Planning Application No: 3/2026/0576

Proposal: Proposed change of use from residential dwelling to holiday let.

Location: Highcliffe Cottage Lower Chapel Lane Grindleton BB7 4RN

SITE PLAN DRAWING
(scale 1:200)

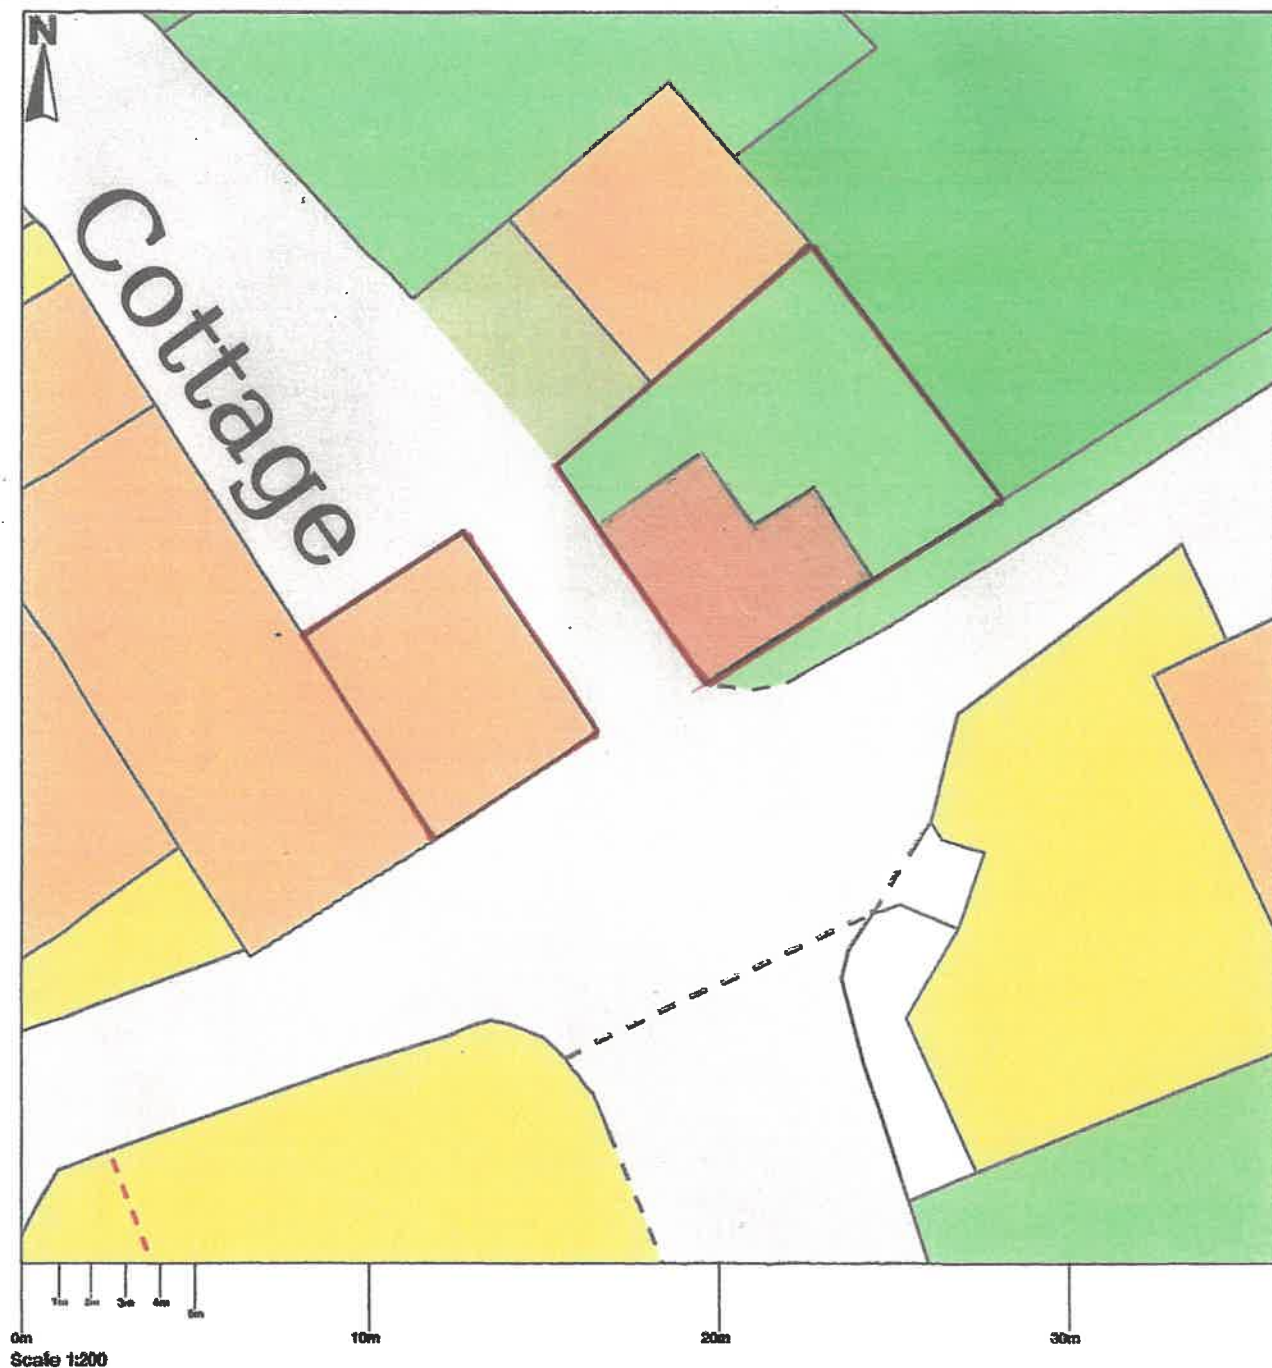
A scaled plan is required to show waste storage, cycle parking and vehicle parking (2 parking spaces 2.4m x 4.8m each in size) for this proposed 2 bed holiday let.
